TRINITY HOUSE

Your Ref: RE: EN010084
Identification No. 20012441

The Thanet Extension Offshore Wind Farm

Response to Issue Specific Hearing 2 (ISH2) : 12 December 2018 Shipping, Navigation and Maritime Safety Issues

## Location Plan

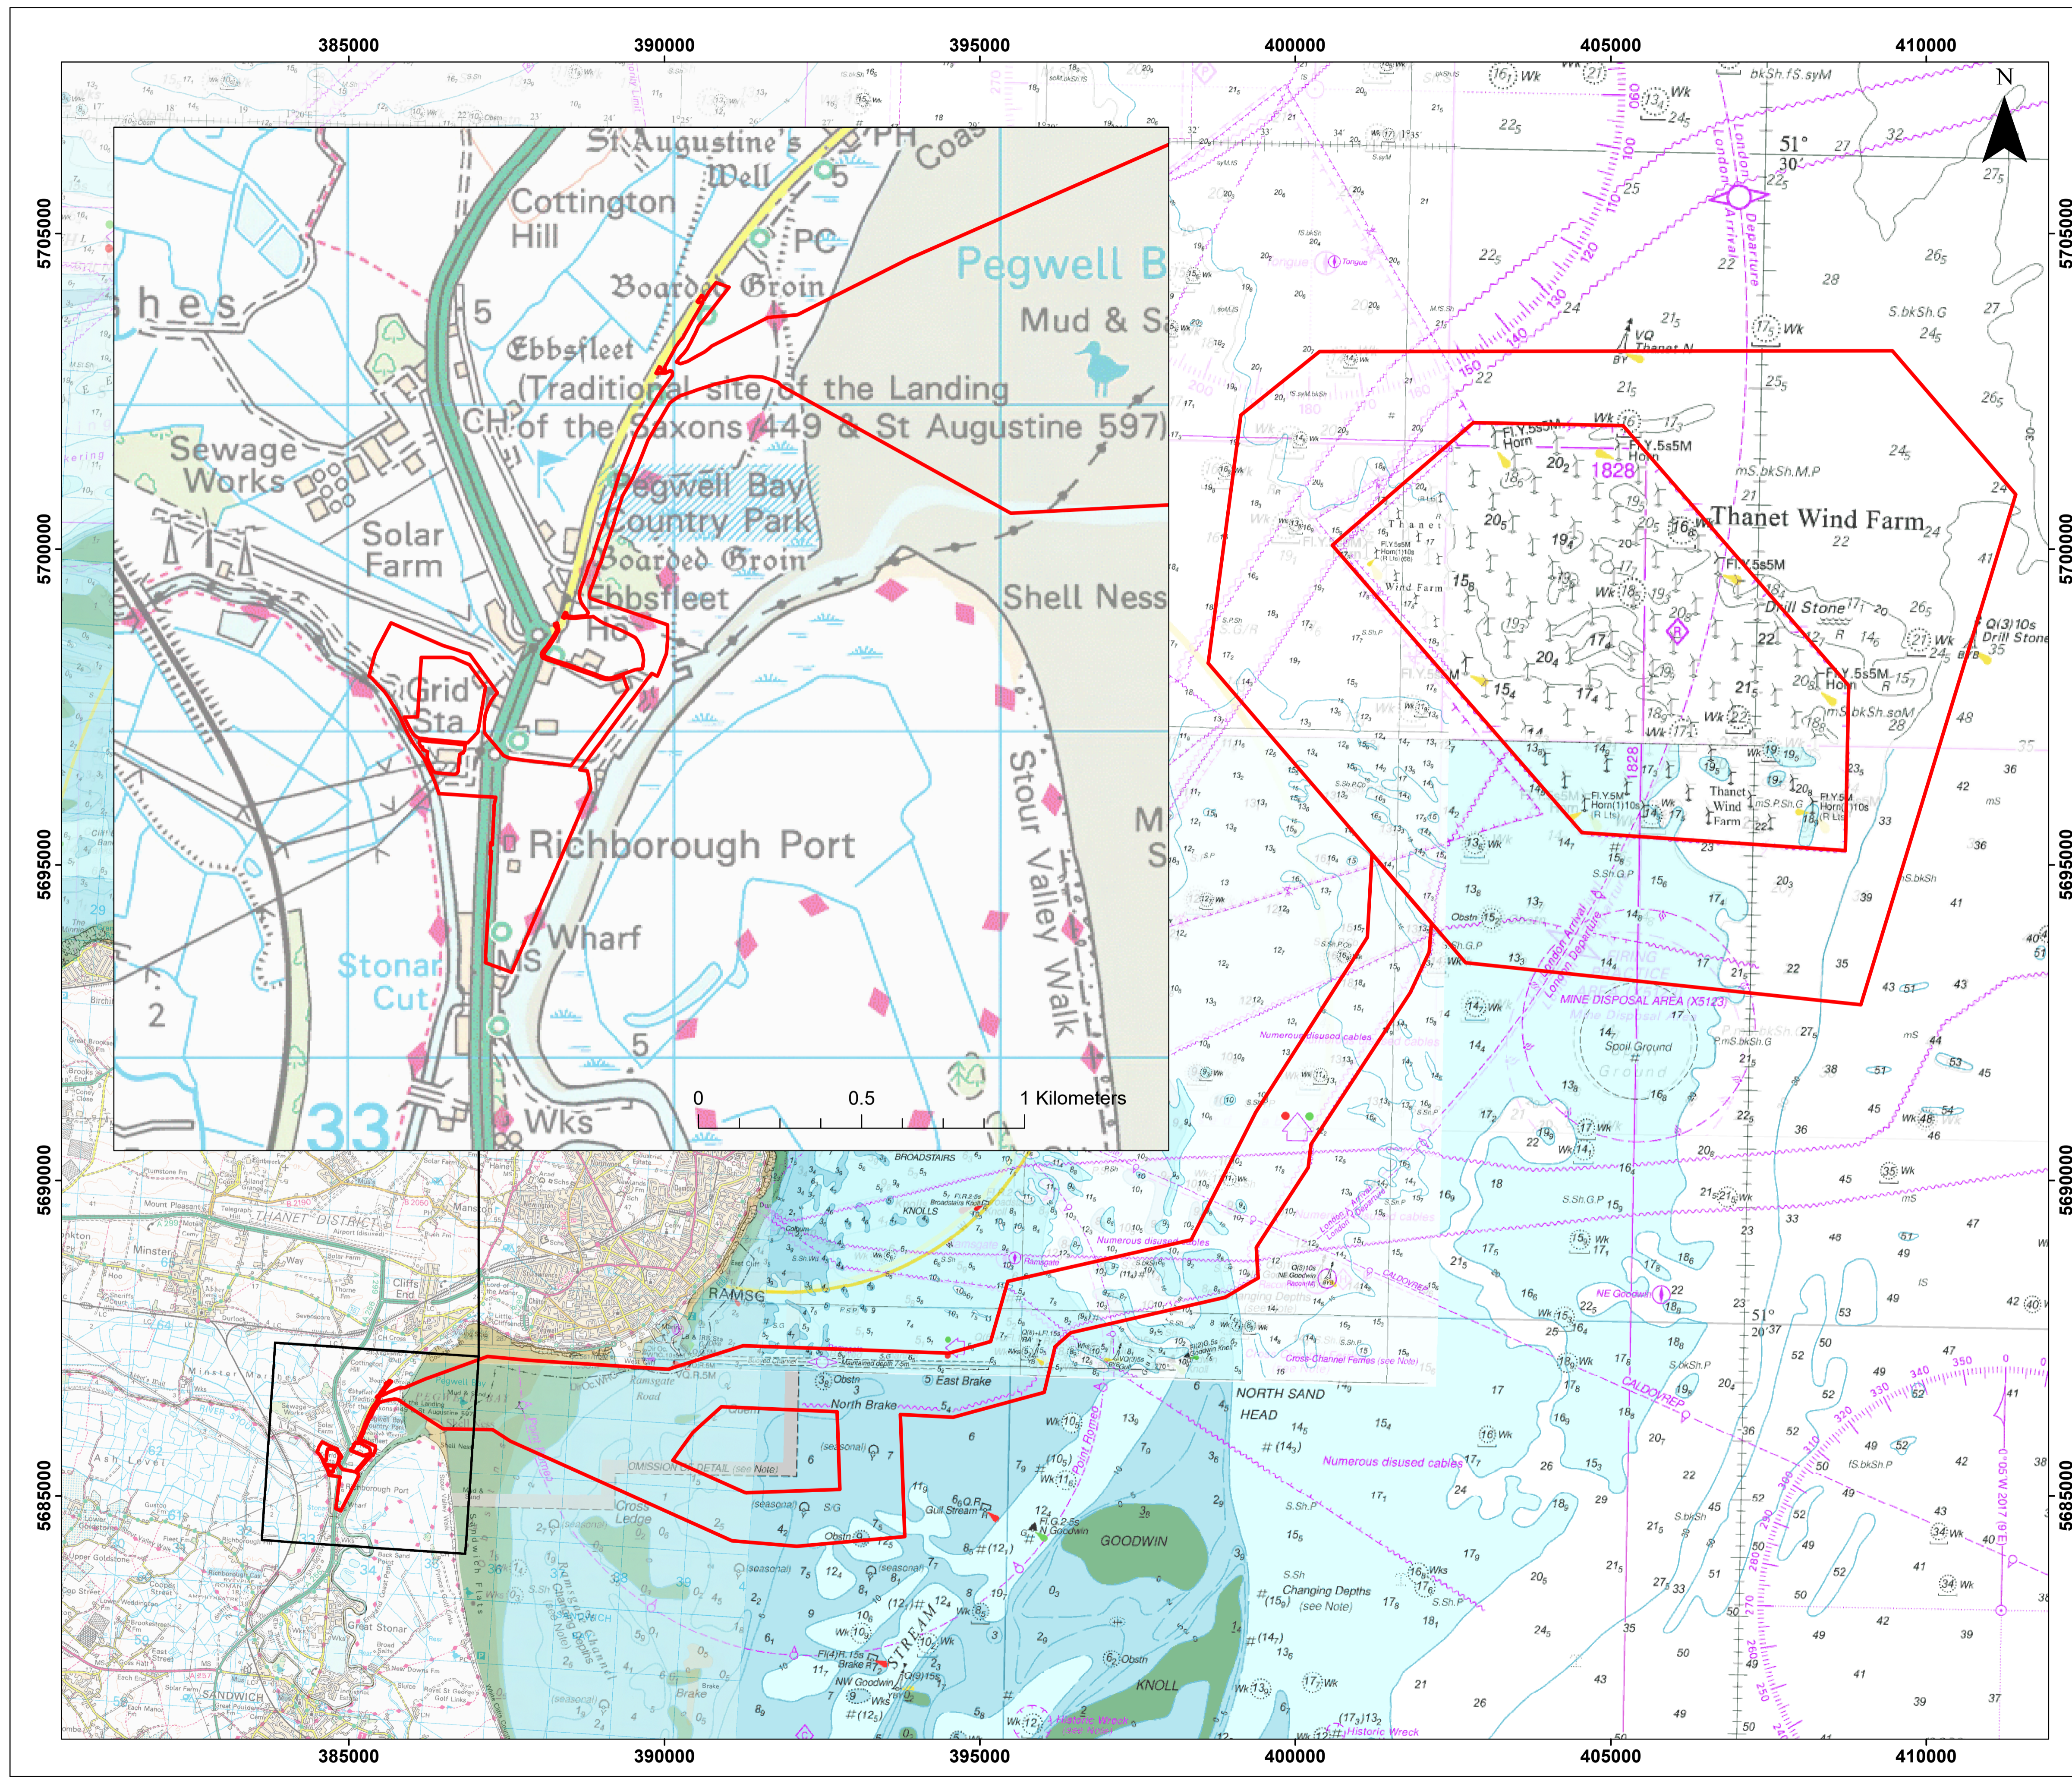
Trinity House object to the proposed red line boundary (RLB) as it will restrict the available sea room for marine traffic between the wind farm and the Kent coast. Shipping will naturally move away from wind turbines and this cannot be shown in the quantitative data, therefore qualitative data must also be considered when considering the RLB. It is also

noted that the RLB does not take into account any construction or operational safety zones which would be applied for at a later date and could restrict traffic further.

Trinity House have a statutory duty to mitigate risk in areas of general navigation and we cannot adequately do that in this area with aids to navigation. If any additional aids to navigation are placed between the proposed RLB and coast this would restrict traffic further.

Hearing Action Points 7 and 11 refer to the red line boundary proposal. Trinity House object to the current proposal and attach our preferred solution below. Our preferred solution takes into account the worst case scenario of turbines being placed on the RLB, and possible 500m safety zones during construction and at various times throughout the operational phase, extending beyond the RLB. We do not consider that the additional risk created by the proposed RLB to vessels navigating between the offshore wind farm and coast can be adequately mitigated and certainly not through the deployment of aids to navigation.

Area requested to be removed from Red Line Boundary
